**RE: SUBMISSION TO SSD-83431958 FOR CONSTRUCTION OF 9 STOREY
RESIDENTIAL FLAT BUILDING WITH IN-FILL AFFORDABLE HOUSING**

Address: 16 & 18 Middle Harbour Road, Lindfield

ATTACHMENT 1

Ku-ring-gai Council's objection to SSD-83431958, for construction of 9 storey residential flat building with in-fill affordable housing at 16 & 18 Middle Harbour Road, Lindfield

Drawing Name
Landscape Composite Masterplan

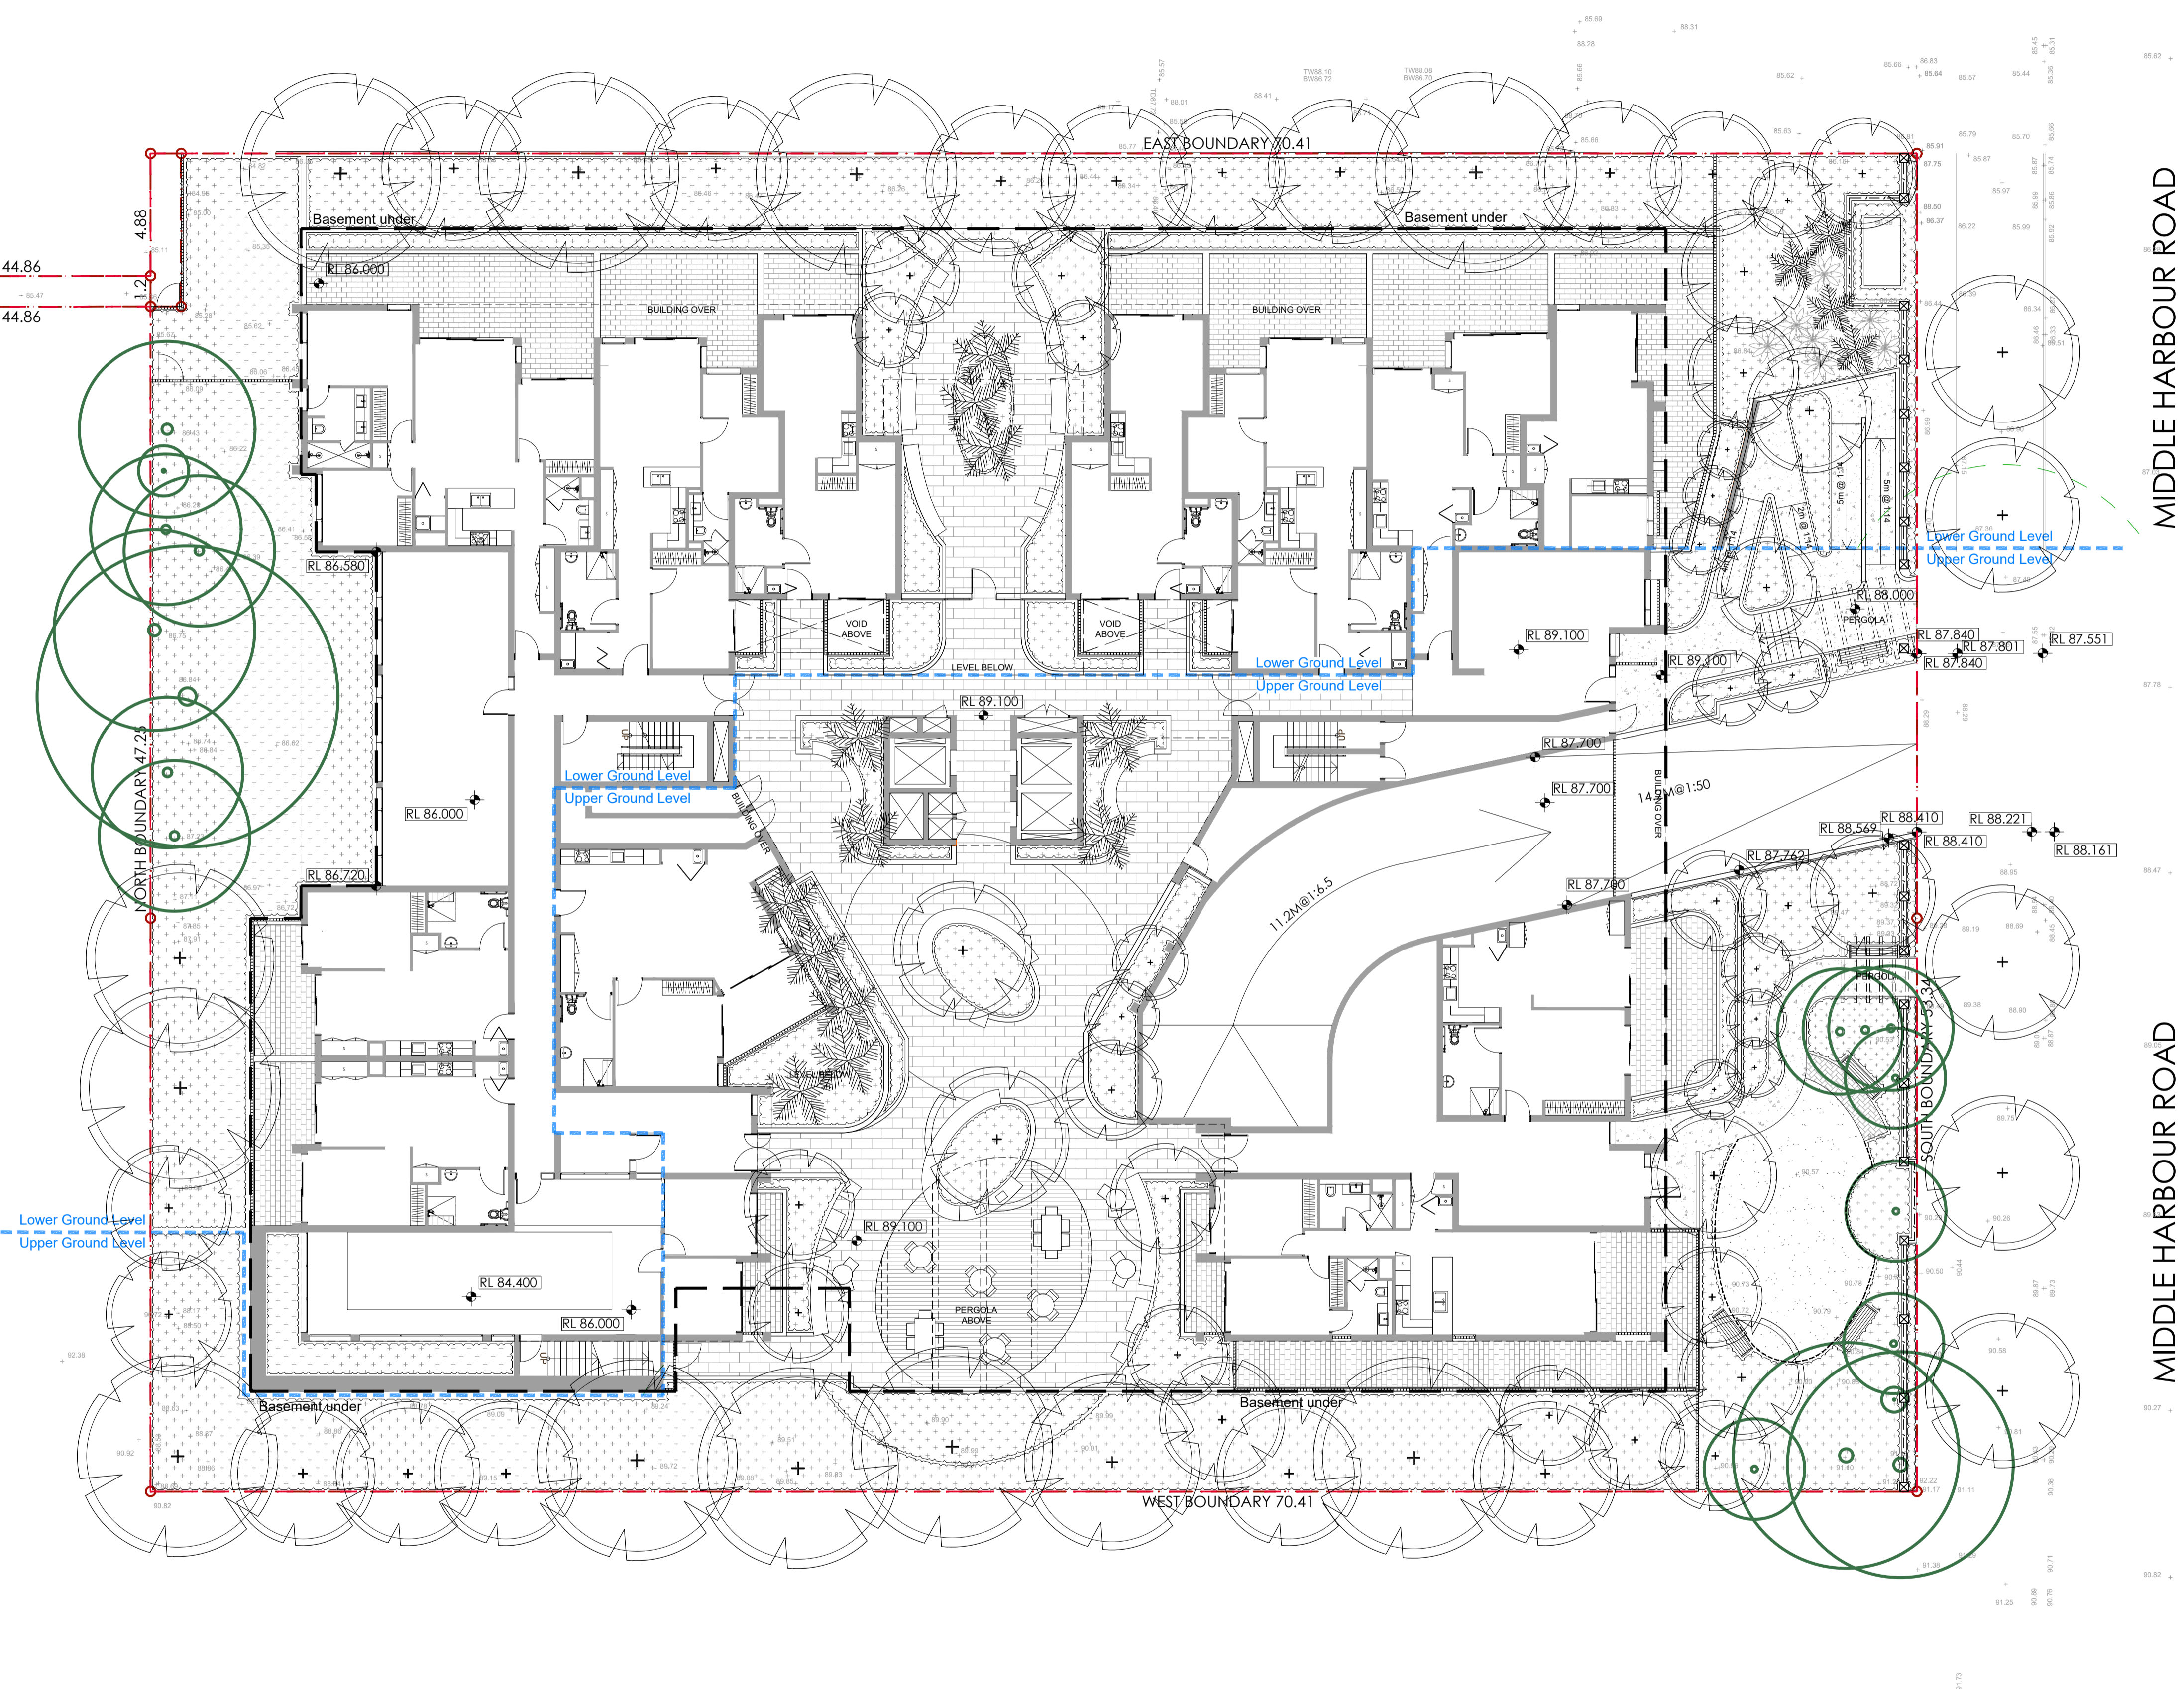
Under the proposed development, some of the communal open space is fragmented and consists of narrow strips of landscaping along site boundaries, which the submitted landscape plans indicate will be planted with shrubs and ground cover. These areas cannot reasonably be considered communal open space under the ADG definition, as they are not usable or capable of supporting recreation or social interaction. Furthermore, the majority of the communal open space located on the lower ground level to the east is covered by the building above at the upper ground level, significantly diminishing solar access, amenity, and usability.

Figure 2: The lower and upper ground floor plans highlighting in green where the COS is located, many of which is not useable as shown on the Landscape Composite Masterplan

Council considers that the design of the communal open space must be revised to ensure compliance with intent of the ADG. Consolidated, uncovered, and genuinely usable areas should be provided that deliver opportunities for active and passive recreation, social interaction, and landscaping amenity. Boundary planting and residual covered spaces should not be counted towards the communal open space provision, as this undermines both the quality of the development and the amenity of its future residents.

DRAWING TITLE:  
**UPPER GROUND / LEVEL 1  
FLOOR PLAN**

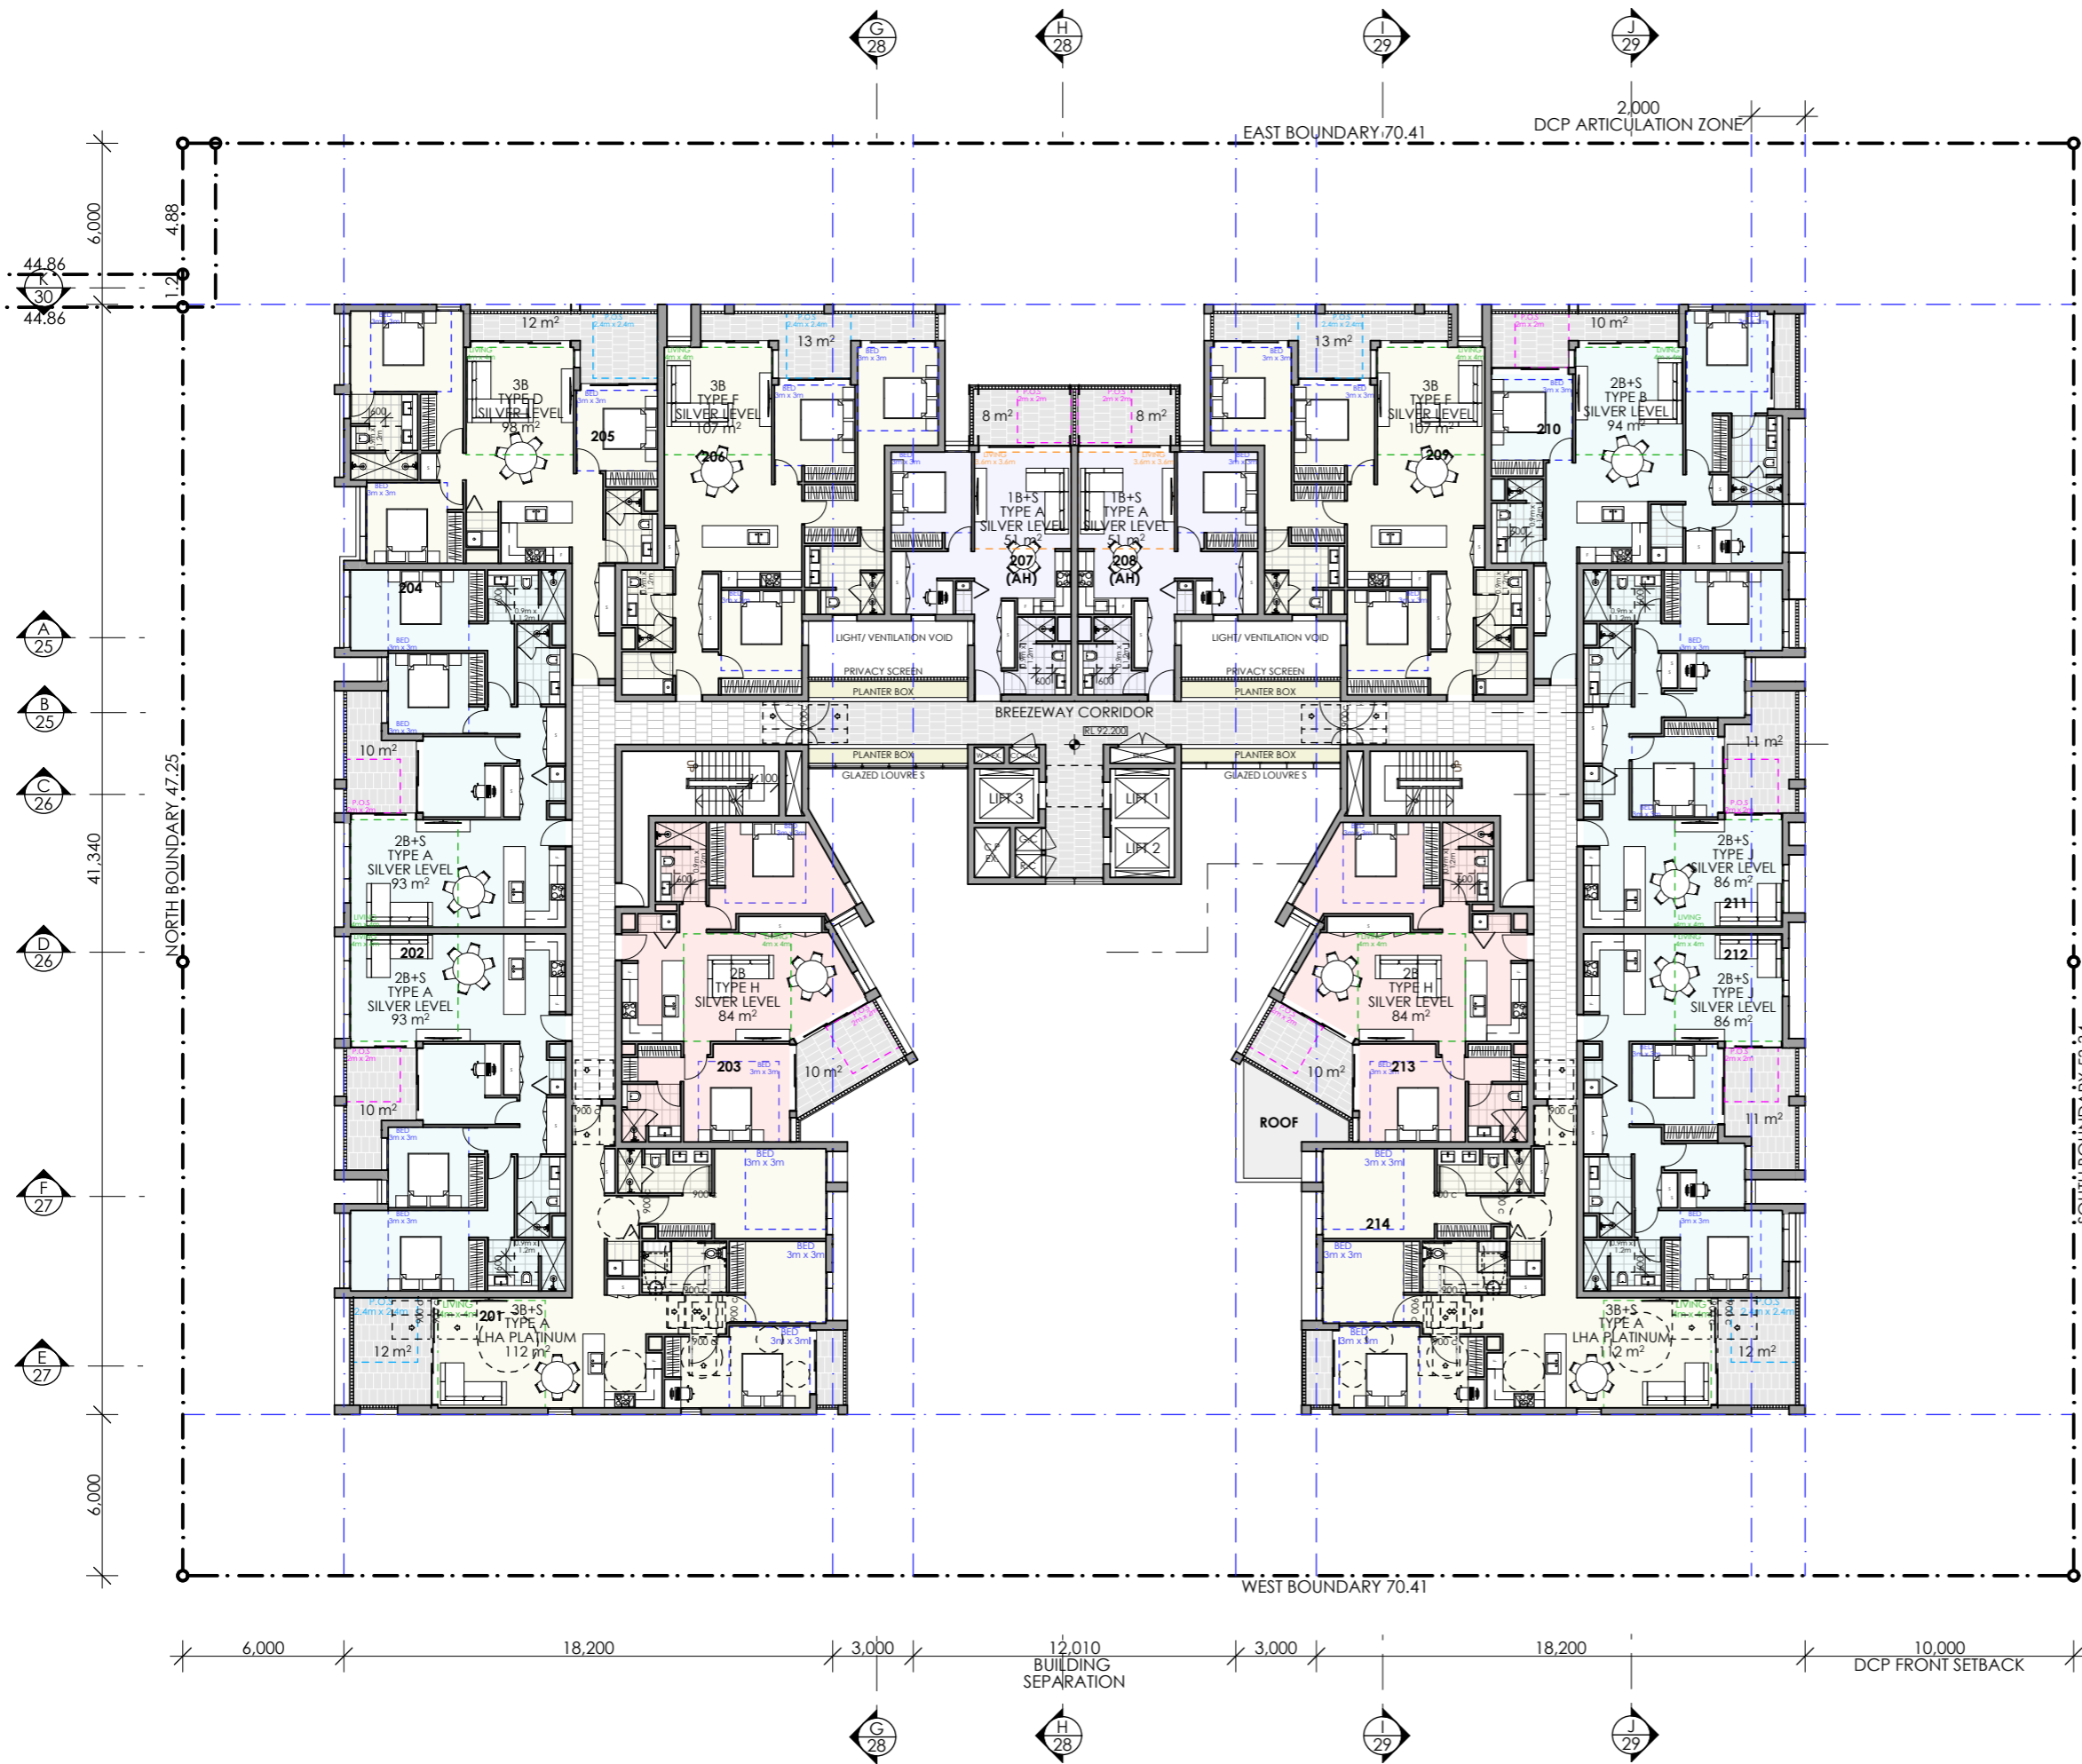
Under the proposed development, vehicle access is located centrally on the Middle Harbour Road frontage. This placement creates a large void in the middle of the façade and visually dominates the streetscape (see Figure 4), contrary to the ADG's guidance. The design further detracts from the quality of the frontage by interrupting opportunities for pedestrian activation and landscaping. The width and placement of the entry exaggerate its prominence, creating a street address that is defined by car parking rather than by welcoming residential entries.

Council considers that the vehicle access should be relocated or substantially redesigned to reduce its prominence, integrate more effectively with the building façade, and allow pedestrian entries and landscaping to take visual priority. Without these changes, the proposal fails to satisfy Objective 3H-1 of the ADG.
